CITY OF PORTLAND BUILDING PERMIT

PERMIT ID: 2012-65665

88 SKYLARK RD

has permission to **New 1 story, 3 bedroom, 2 bathroom (32' x 50') w. attached garage (20' x 22')**
Single Family Home

FLOOR PLAN  
1/4" = 1'-0"

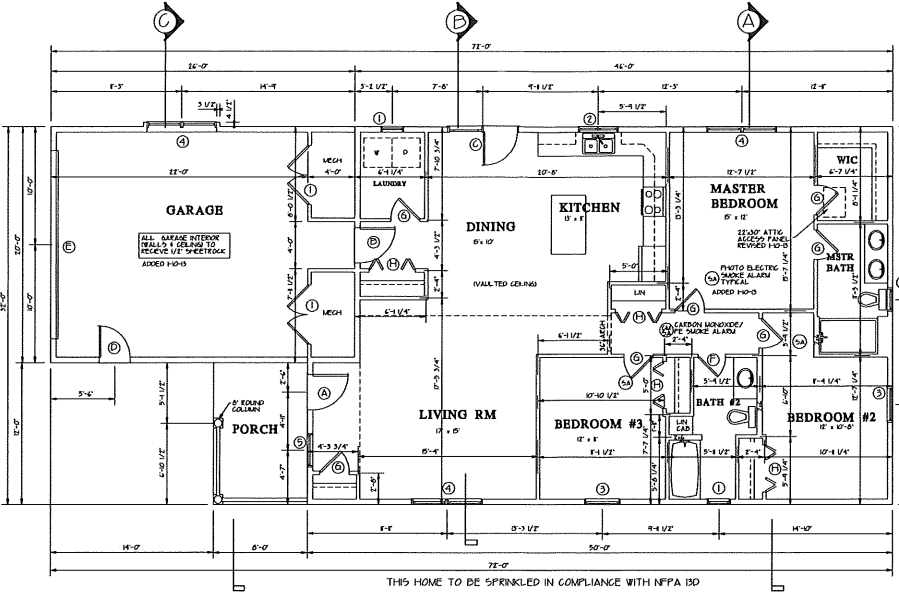
1. Is there a crawl space? Is so it must comply with (Section R408.1 & R408.3)
2. Is the first floor slab on grade, radiant heat?
3. Private Garage (Section R302.5) Beside Living Space (Storage above?) Table R302.6 Fire separation (Section R302.6)?

5. Emergency Escape and Rescue Openings (Section R310), egress windows for each bedroom, finish height?
6. Roof Covering (Section R905)?
7. Safety Glazing (Section R308)?

8. Attic Access (Section R807) (22 by 30 inch is the minimal)?
9. Chimney Clearances/Fire Blocking (Chap. 10)?
10. Header Schedule (Tables R502.5(1) & (2)) 2 by 10 inch for each window?

11. Number of Stairways
12. Interior, from garage?
13. Exterior?
 - a. Treads and Risers (Section R311.5.3)
 - b. Width (Section R311.5.1)
 - c. Guardrails and Handrails(Section R312 & R311.5.6 – R311.5.6.3)

14. Carbon Monoxide Alarms (R315)?
15. Smoke Alarms (Section R314)?
 - a. Location and Interconnected
16. Deck Construction (Section R502.2)?

1. No crawlpace anywhere.
2. Yes its slab on grade, possibility it will be radiant heat, client has not decided.
Refer to Foundation Plan for insulation locations.
3. Added note to Floor Plan & Bdg. Section B indicating Garage interior (walls & ceiling) to have 1/2" sheetrock.
5. Revised note of window # 3 & # 4 in window schedule. This unit meets egress requirements with a finished sill ht. of 24 1/2".
6. Changed note on Bldg. Section A to indicate roofing to asphalt roof shingles.
7. Revised note of window # 5 in window schedule to indicate tempered glass req.
8. Revised size to 22"x30" on plan.
9. No chimney. Lp direct vent furnace.
- 10.(3) 2x10 headers at all openings.
11. None
12. None, (1) 6" step.
13. None.
14. Carbon Monoxide/photo elec. smoke alarm indicated on plan in hall outside of Bedrooms.
15. Photo electric smoke alarm locations indicated on plan in Bedrooms.
16. None.
